Gateshead Council's Responses to ExQ3 of TR010031

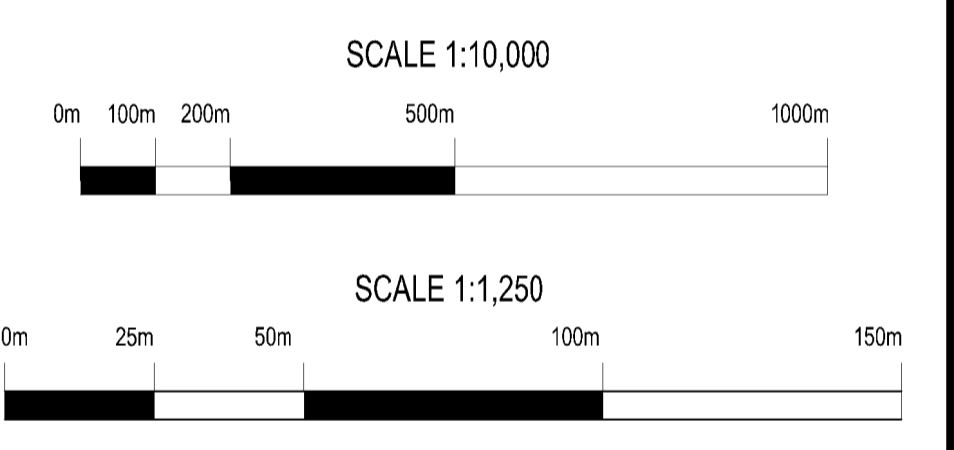
All the above items have now been agreed in principle, with any detail to be managed through development of the detailed CEMP and/or the proposed CTMP working group, with the exception of item 2. Diversion routes for horse riders and other users in the vicinity of Eighton Lodge roundabout in particular remain a concern and require further discussion.

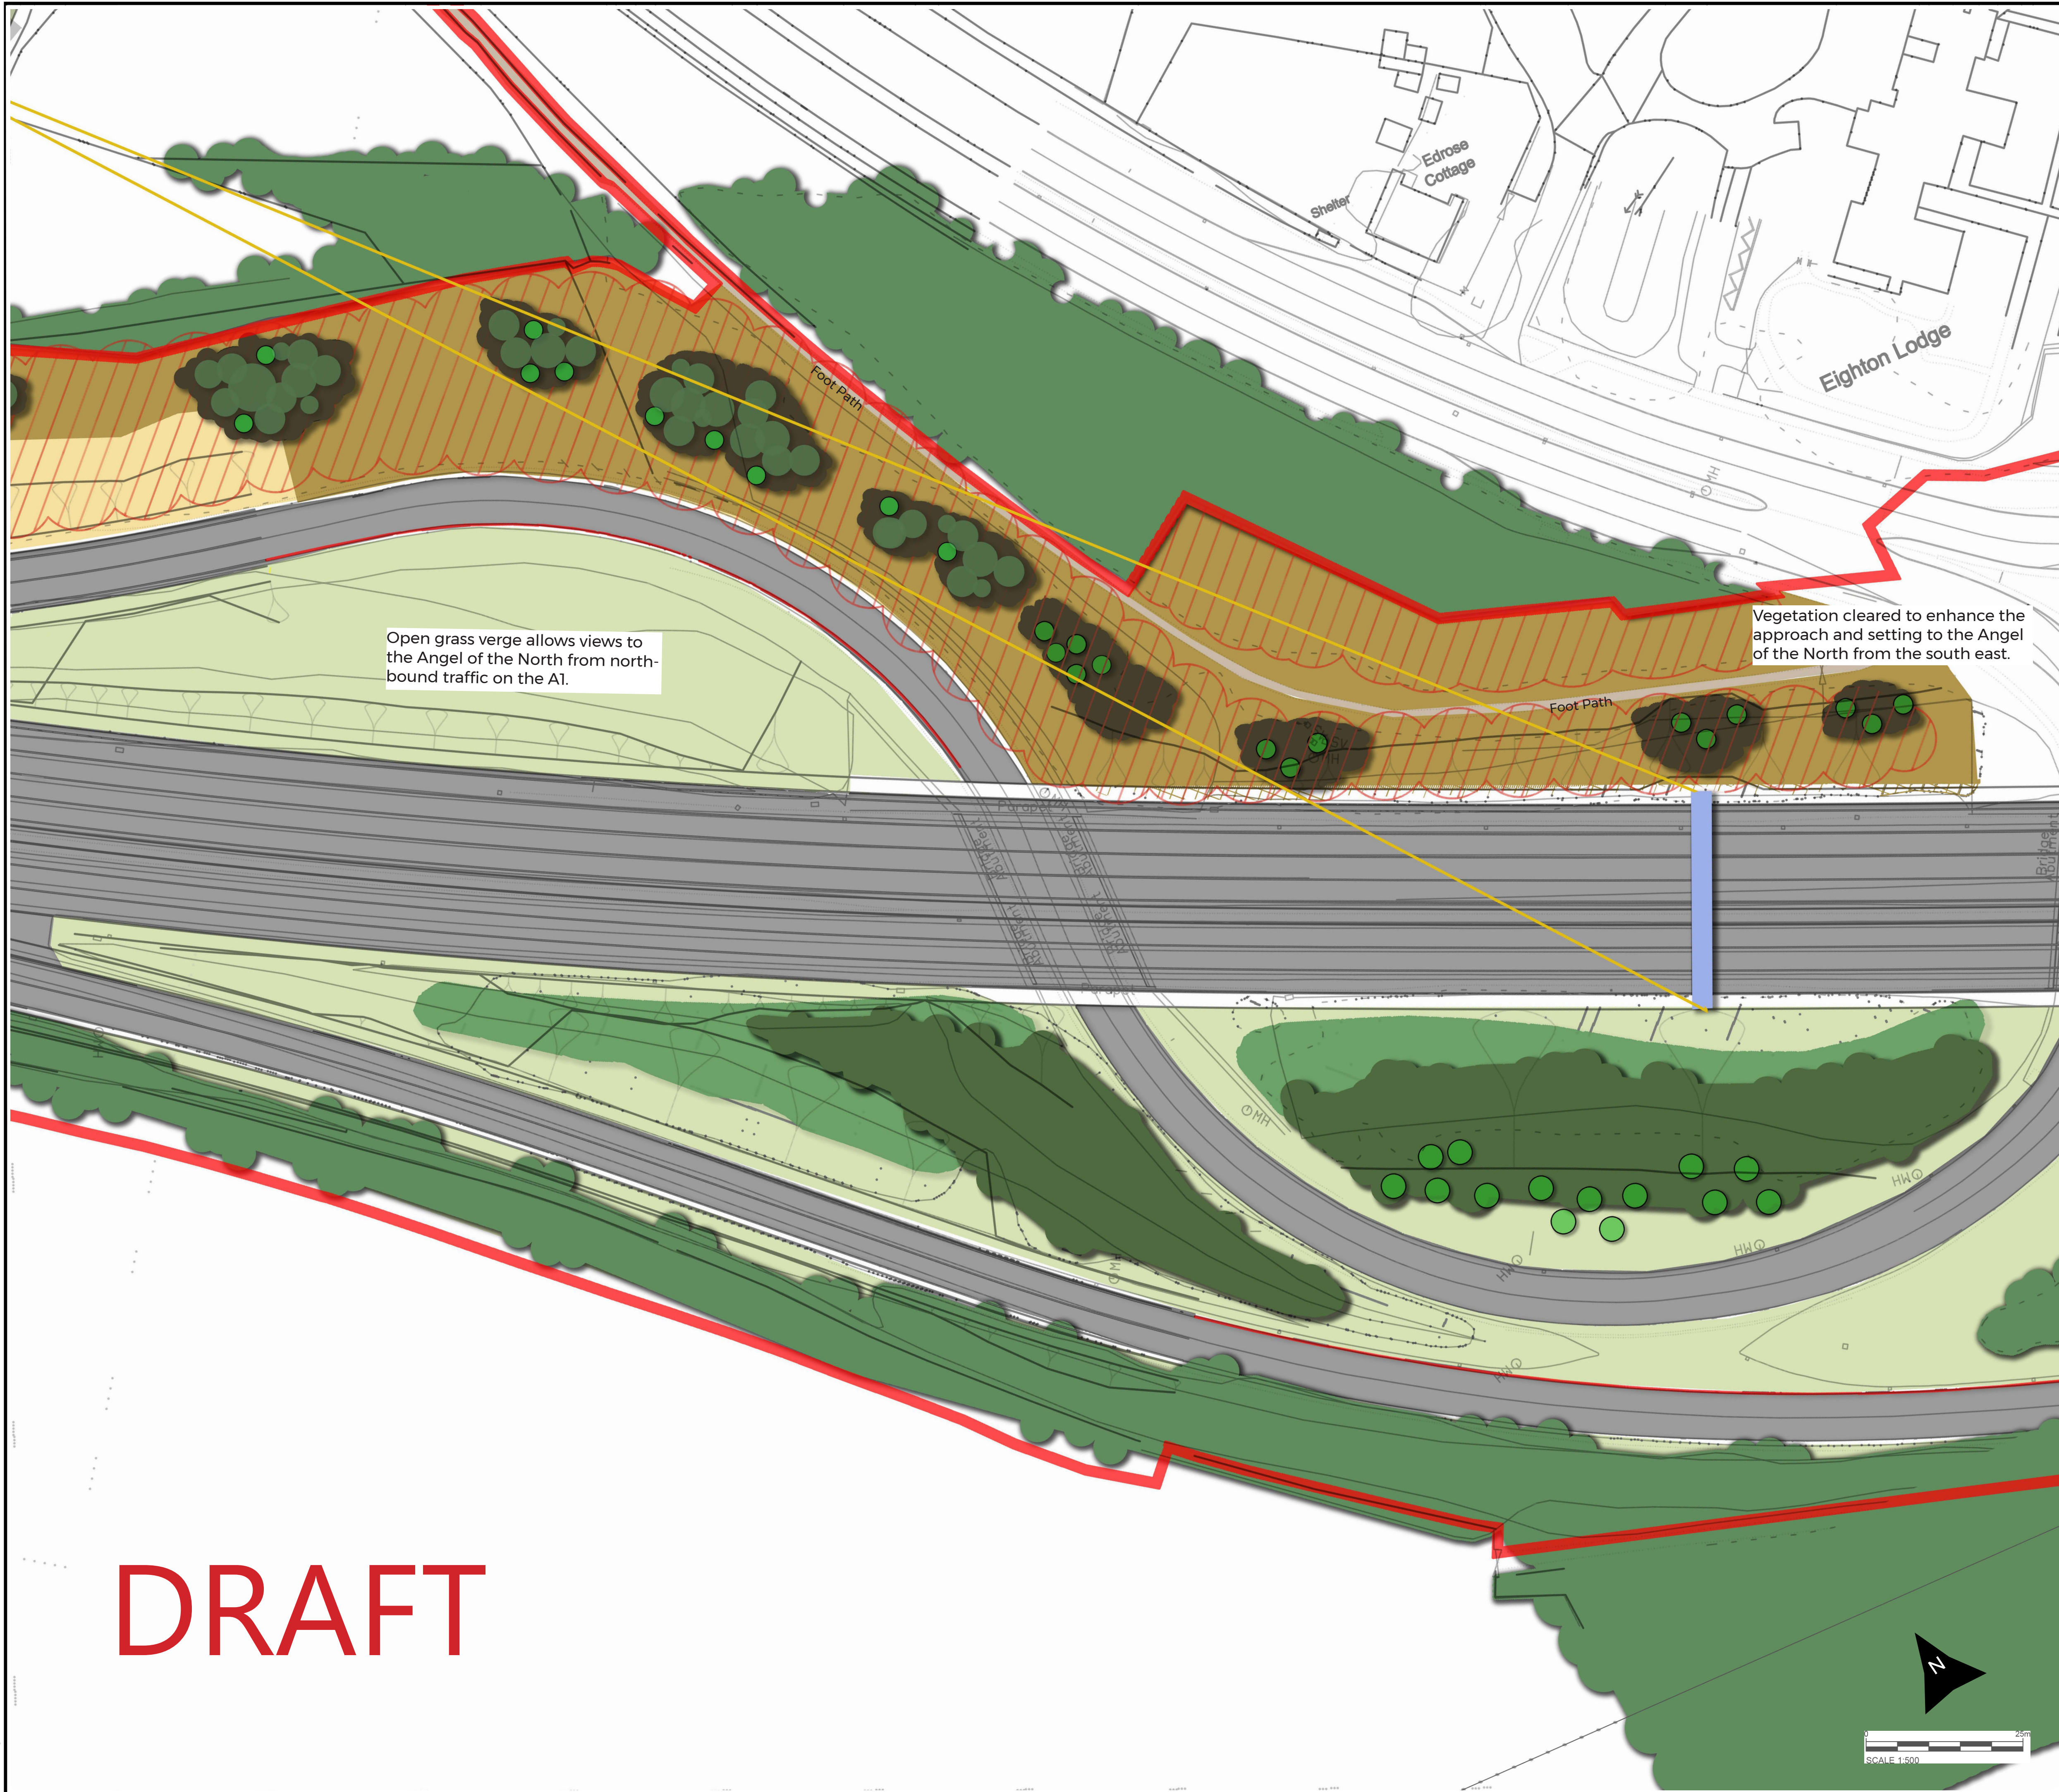
3.6.4 – The opportunity to agree the final design and location of gantries would allow the landscape scheme to respond to their impact in a positive manner and ensure that any harm to significant views of the Angel were mitigated where possible.
